# Planning and Urban Development Department

**Subject:** IOZ Design Review – 22 Bramhall (Maine Medical)  
**Written by:** Caitlin Cameron, Urban Designer  
**Date of Review:** Friday, March 16, 2018

This memo summarizes the applicable design guidelines and staff review for the projects at 22 Bramhall Street – East Tower and Visitor Garage expansion. These two projects are reviewed according to the adopted IOZ IDP and Regulatory Framework standards.

Fig.5.18 Computer-generated shadow study / Proposed long-term projects on June 21, noon

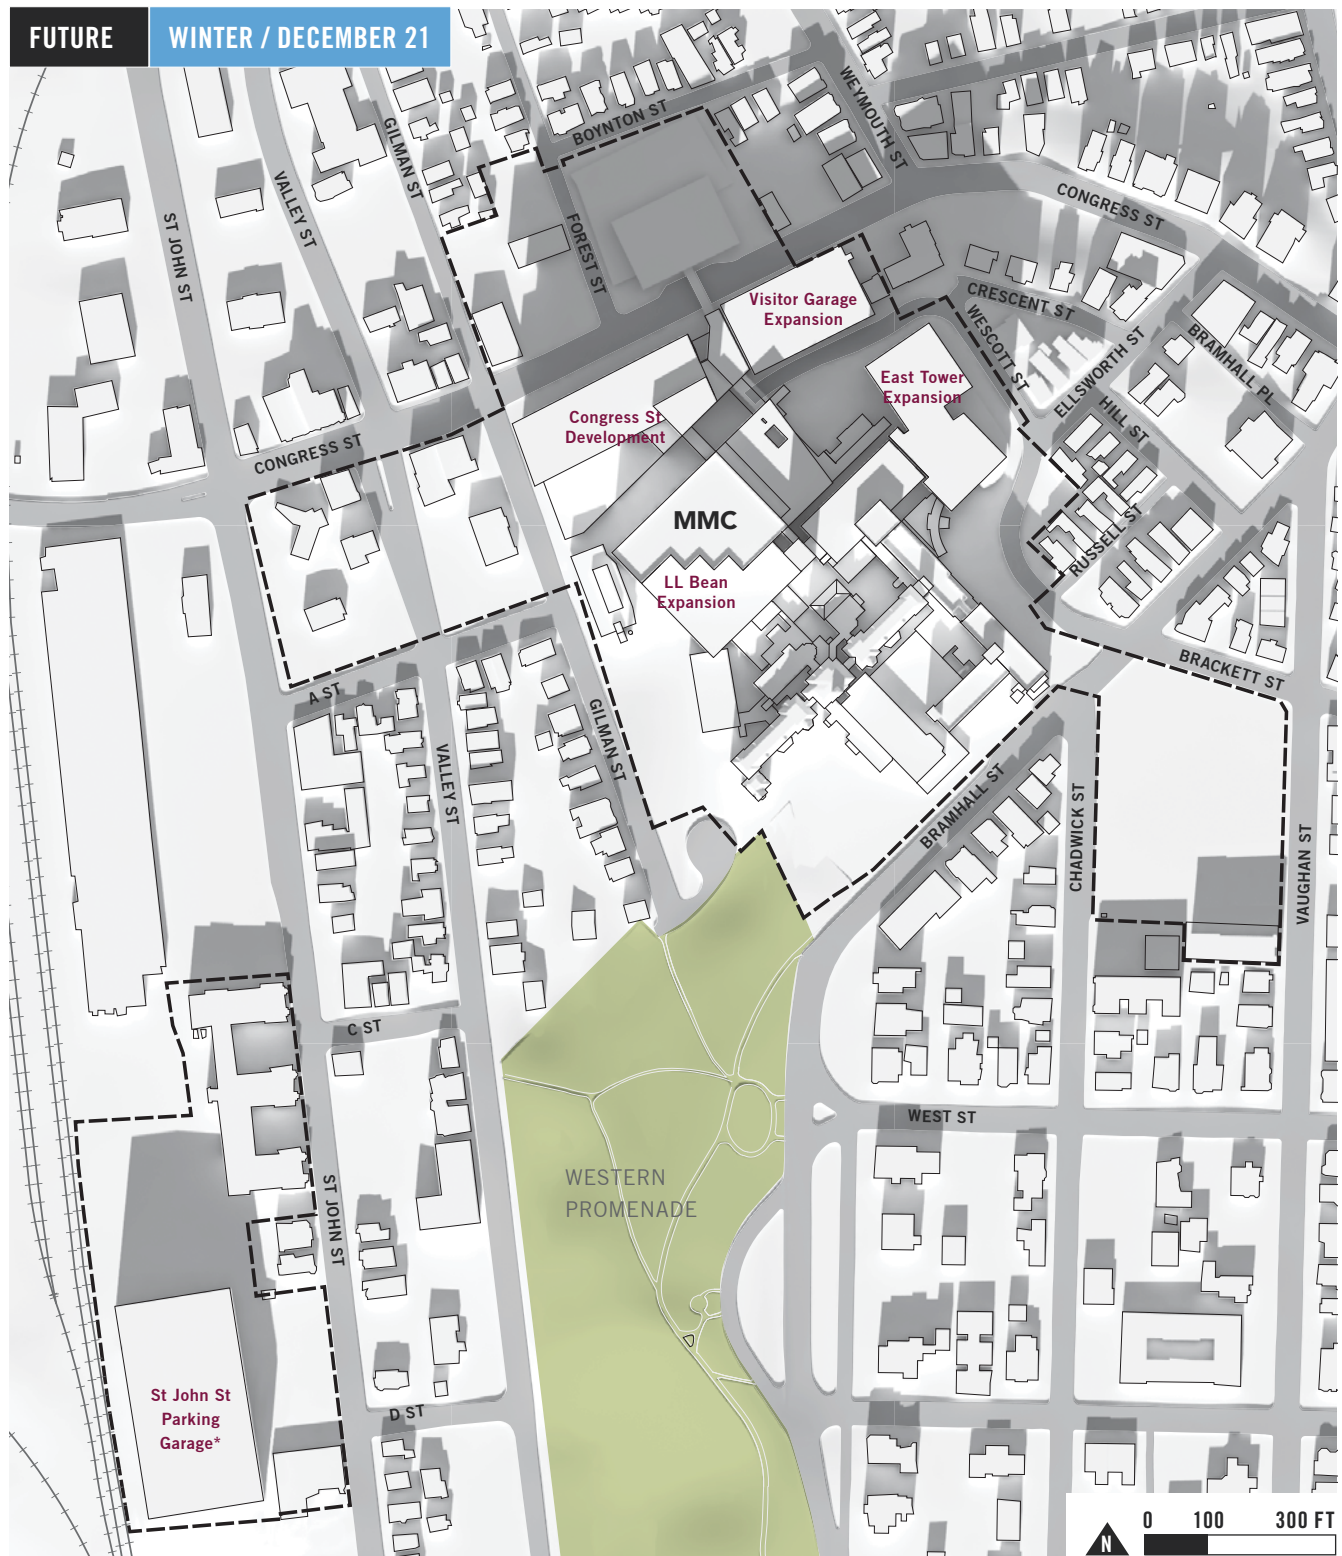
*Minimizing Shadow Impacts* - Shadow impacts were evaluated as part of the IDP process. Both projects increase building height and will inevitably have some shadow impact – the garage height will increase the shadow cast across Congress Street but, as the applicant has argued, shadows on Congress Street are unavoidable due to the terrain, orientation, and street position. Refer to Plan 13 for shadow analysis of the approved IDP building heights – a couple of residential buildings are impacted in the winter by the increased height.

I-295

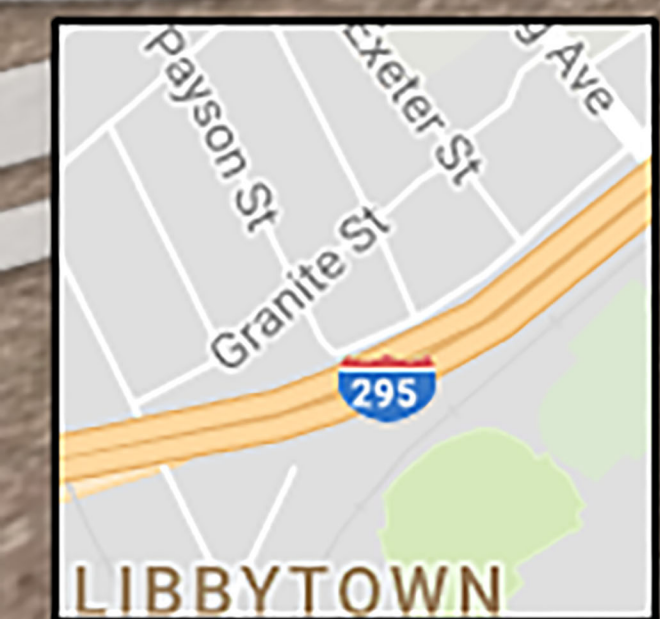
East Tower: **Planning Board generally found that the proposal is cohesive with the future vision as presented in the 2/27 materials.** The applicant provided a view from I-295 that further demonstrates the intent for the East Tower expansion to visually contribute to the planned new character of the campus. The white material selection is intended to be a cohesive element throughout the campus moving forward.

NORTH ELEVATION

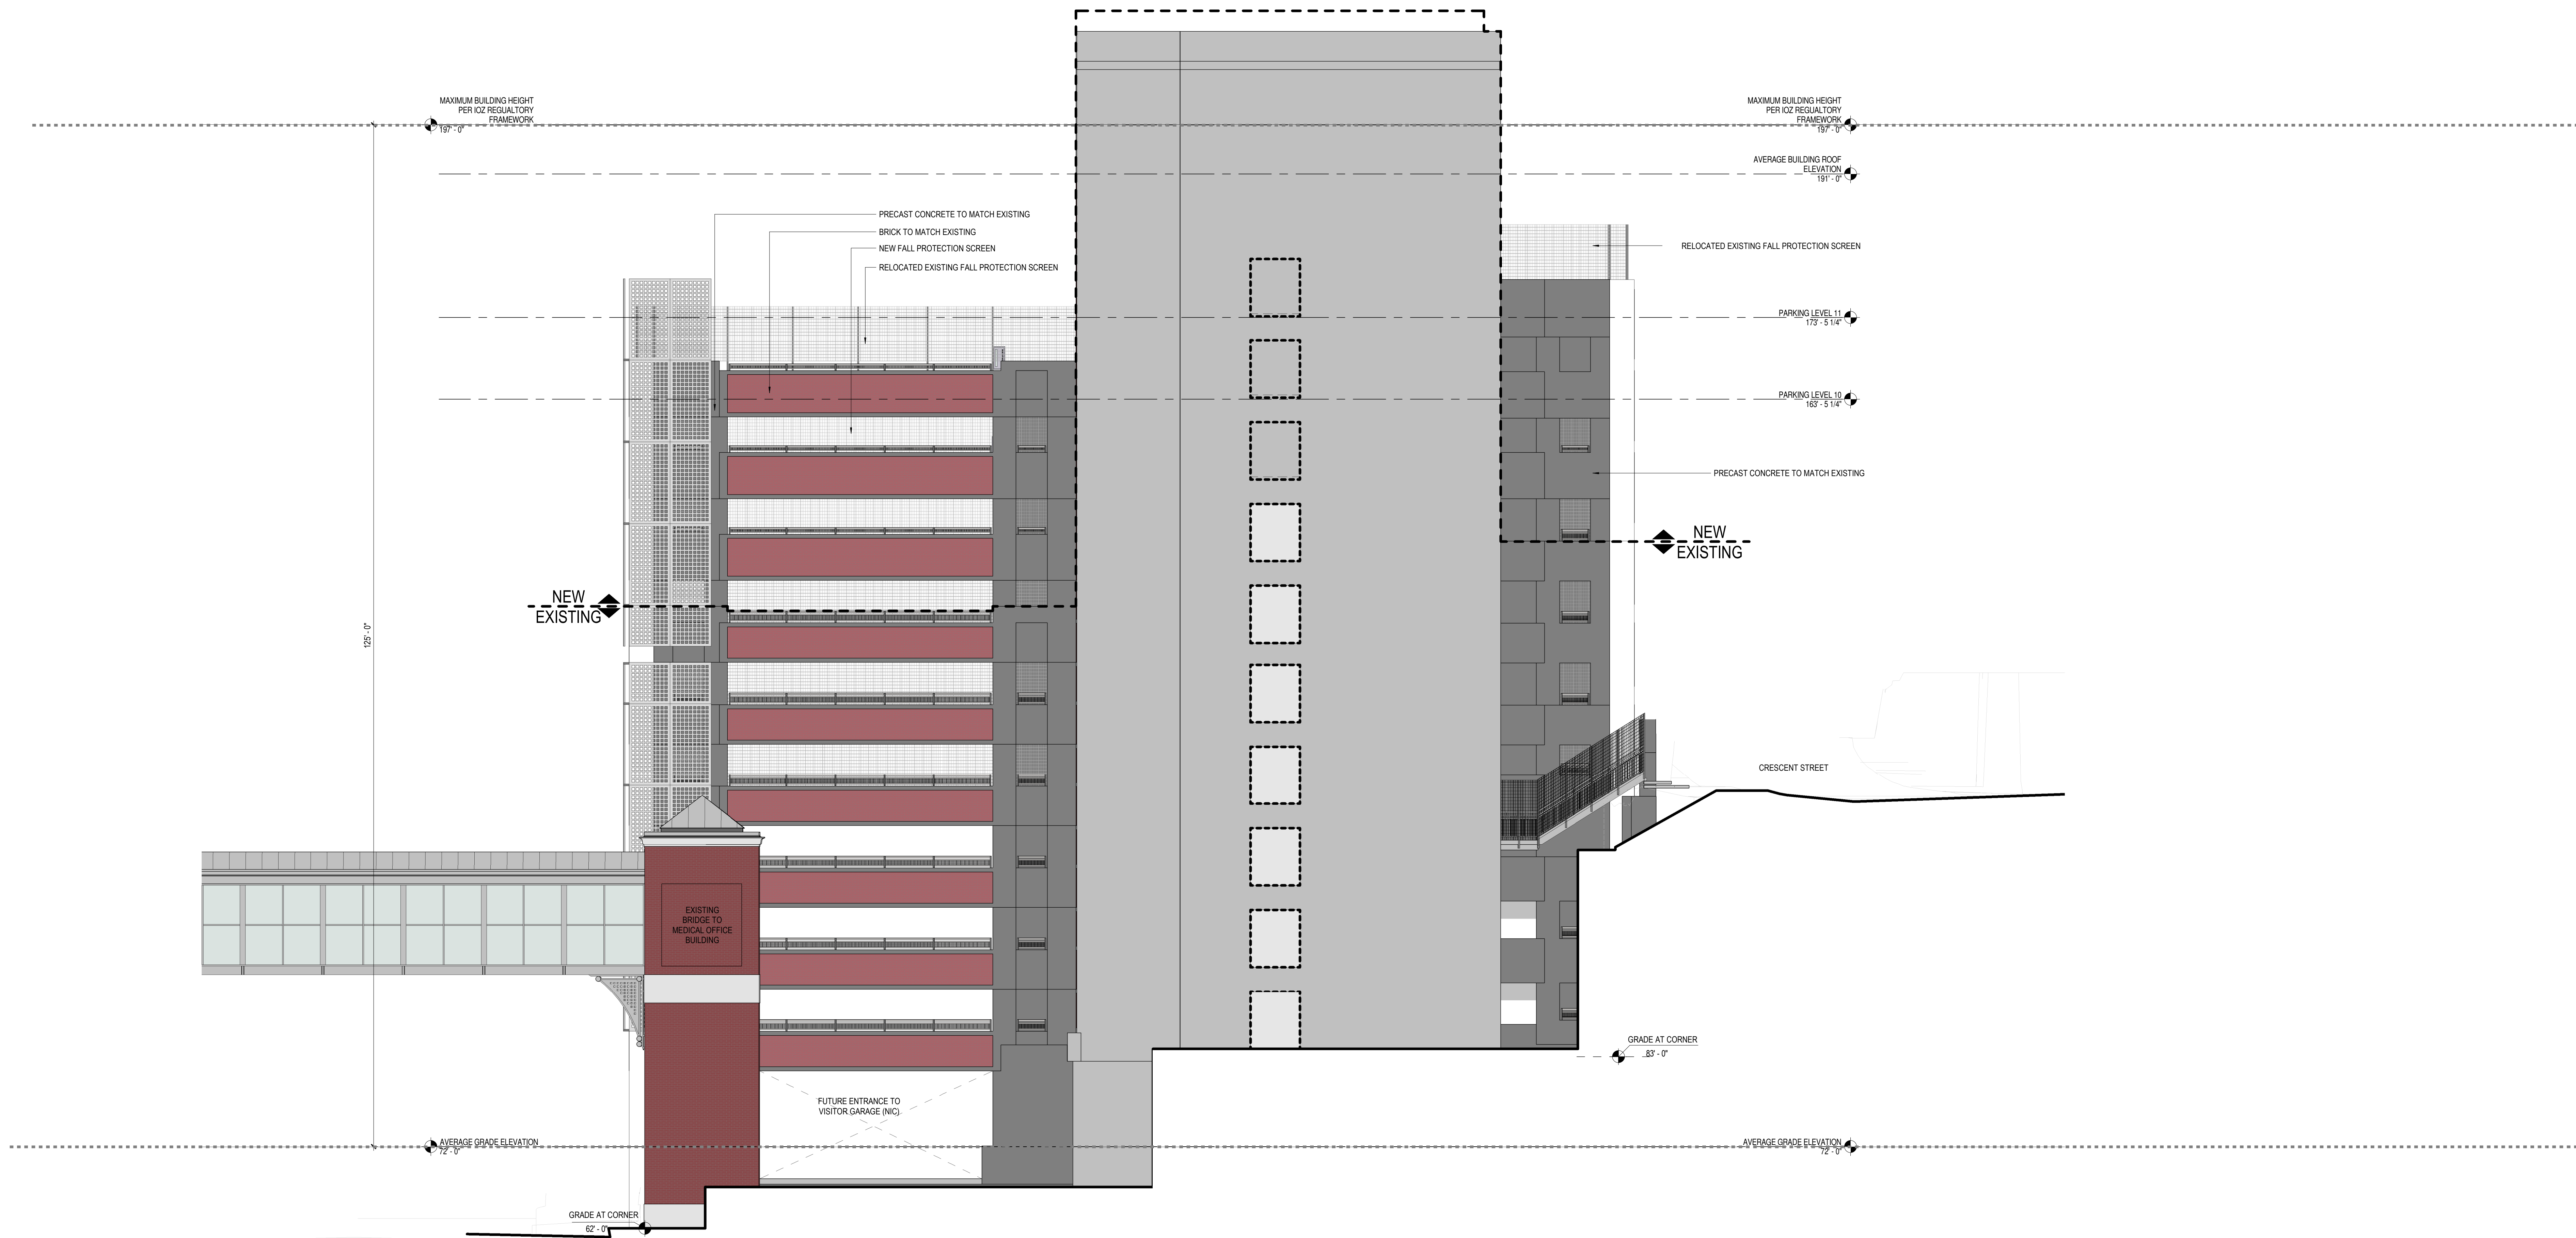
Visitor Garage: **Congress Street is a major street and this building will become even more visible from long views as it grows in height. The garage proposal lacks visual interest from long views – articulation and visual interest are important for the garage in the forefront of the campus. Planning Board asks that the applicant re-evaluate the approach. The roofline is an element where visual interest could be added - Planning Board commented that the simple roof form does not have enough visual interest for the long views.** The applicant revised the screens in response to these comments. The screens will extend higher to provide a varied roofline that also screens the fall protection fence. The screening will wrap around the corners. There will be a reveal between the existing and new screens to give a visual break, as well as a literally break between the existing and new construction. These elements address the Board comments by adding some dynamic elements to the roofline in a way that is structurally feasible.

Visitor Garage: The architectural character remains largely the same as the existing condition and is found to be consistent with the established character. The building addition increases the visibility of the campus from those long views. The applicant revised the screens to extend above the top deck, addressing the comments about the visual interest of the roofline.

Visitor Garage: The massing, roof forms, rhythms, and material relationships remain mostly unchanged from the existing conditions. The screens will be extended up and around the sides of the building to further address the desire to for visually interesting roof lines.

WEST ELEVATION

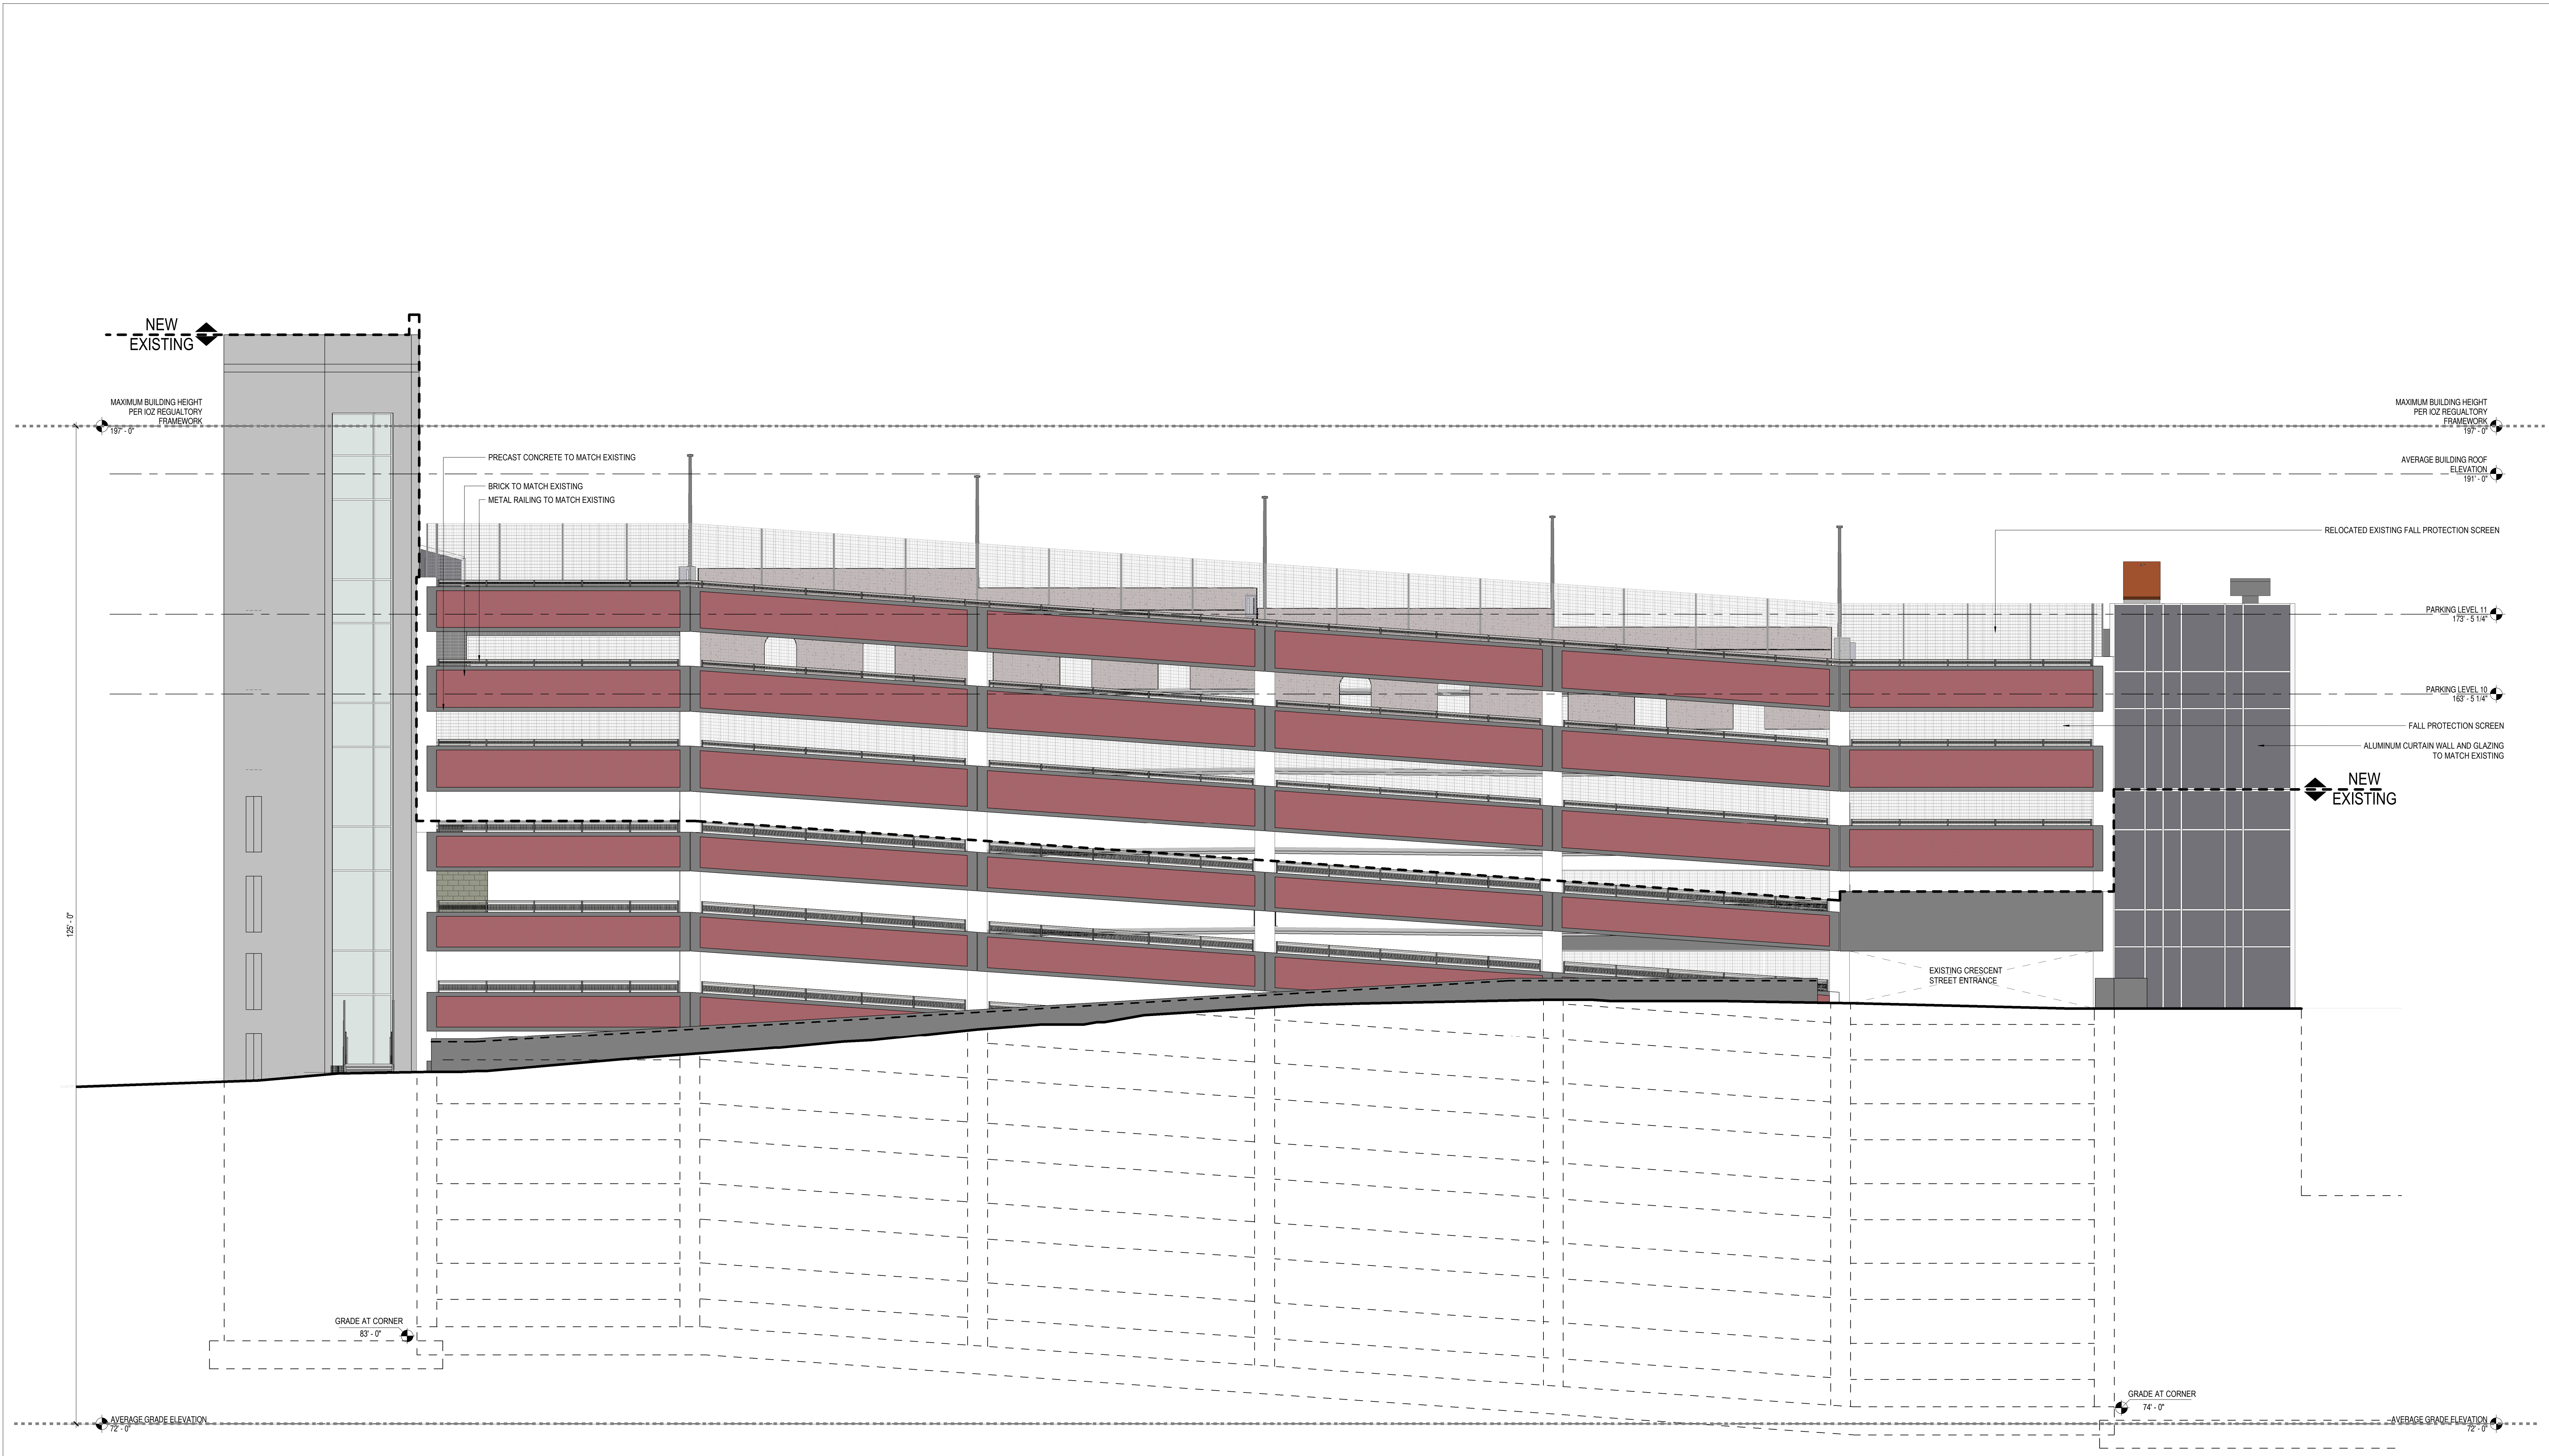
Visitor Garage: The proposal maintains the existing material palette of brick, concrete, and metal screen. **Planning Board is concerned about the prominence of the garage on Congress Street and the lack of visual interest and contribution to the public realm by using the existing material palette.** In response to the Planning Board’s comments, the applicant revised the elevation to extend the screens above the top deck adding visual interest to the roofline, screening the fall protection. There is a gap between the existing screen and the new screen to add some visual relief and to differentiate the existing from new façade. These screens will wrap around the corners of the building.
